From: Simon Davis
Sent: 23 July 2019 14:41
To: James Hutchison [REDACTED]
Subject: RE: Y/32/19/RES - Land Adj Lake Barn. Maypole Lane, Yapton

Drawing title Proposed Floor Plans

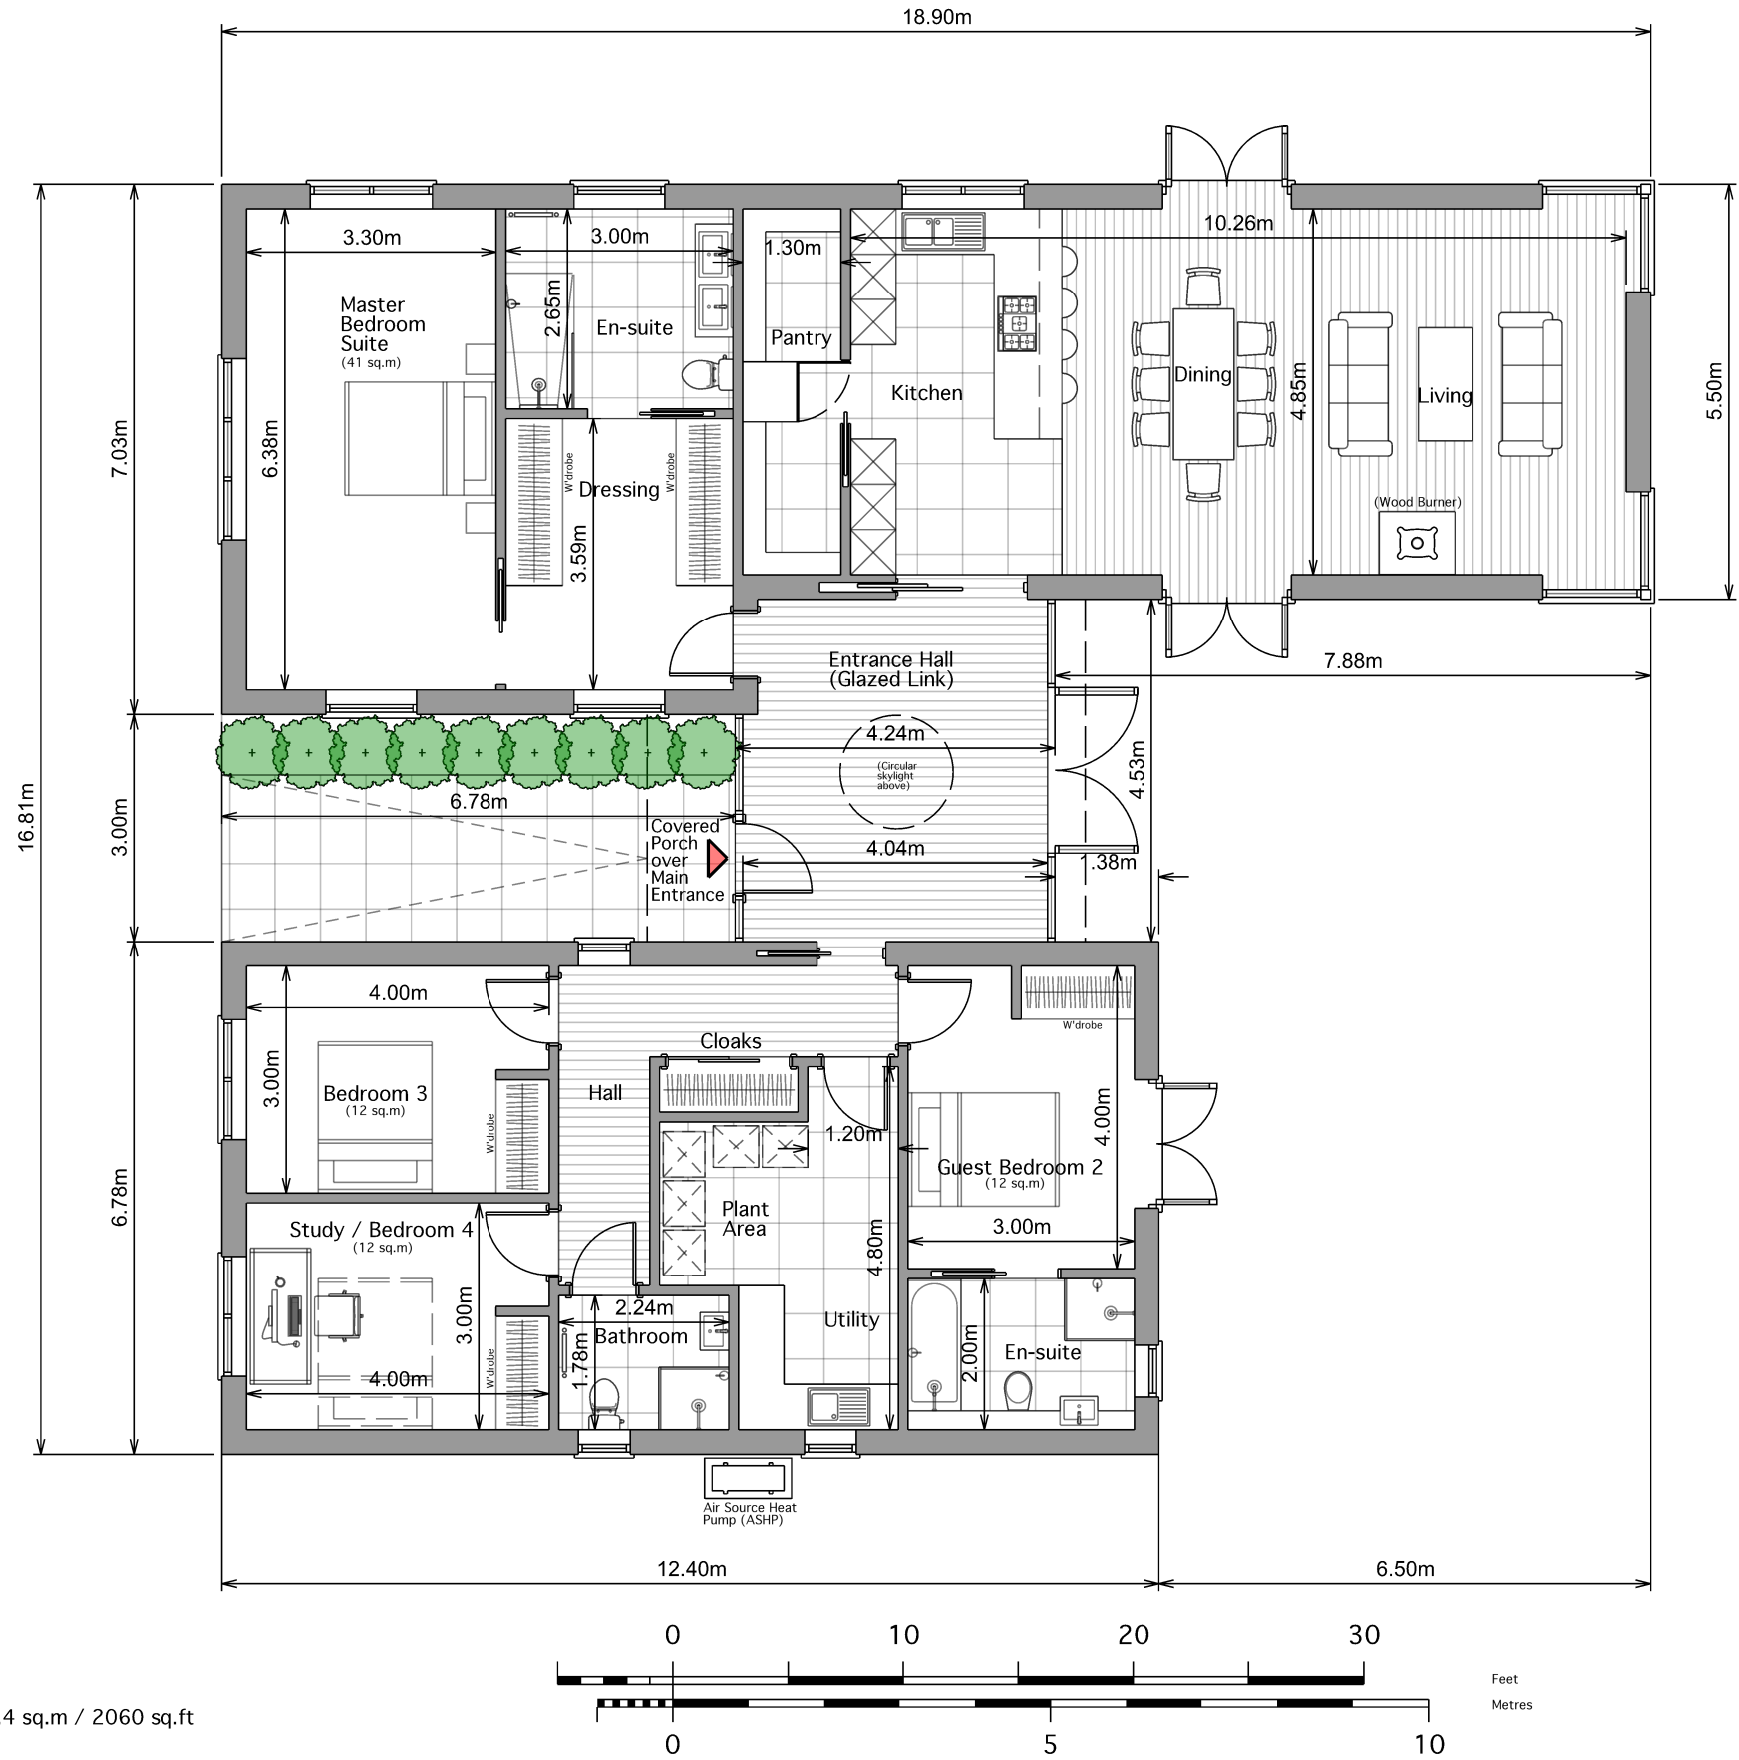
- (a) You would like us to reduce the width of the access and driveway to strictly follow the outline consent; or
 - (b) You are satisfied to proceed with the access as shown on the current plan and condition the same for compliance?
3. I will ask the architect to confirm this detail (car charging points) in a non-material revision to the floor plan.

- (i) More detail on the landscaping scheme / proposed block plan;
- (ii) Car charging point shown on the proposed floor plan.

Please note that a condition will be imposed requiring a strategy for the provision of electric charging facilities. Our standard condition is as follows: *Prior to occupation of the new dwellings, a strategy for the provision of facilities to enable the charging of electric vehicles to serve the approved dwellings shall be submitted to the local planning authority for approval and thereafter implemented in accordance with the approved details and the charge points shall thereafter be permanently retained and maintained in good working condition. Reason: New petrol and diesel cars/vans will not be sold beyond 2040, and to mitigate against any potential adverse impact of the development on local air quality, in accordance with policy QE DM3 (c) of the Arun Local Plan, the Arun District Council Electric Vehicle Infrastructure Study (November 2017) and the National Planning Policy Framework.*
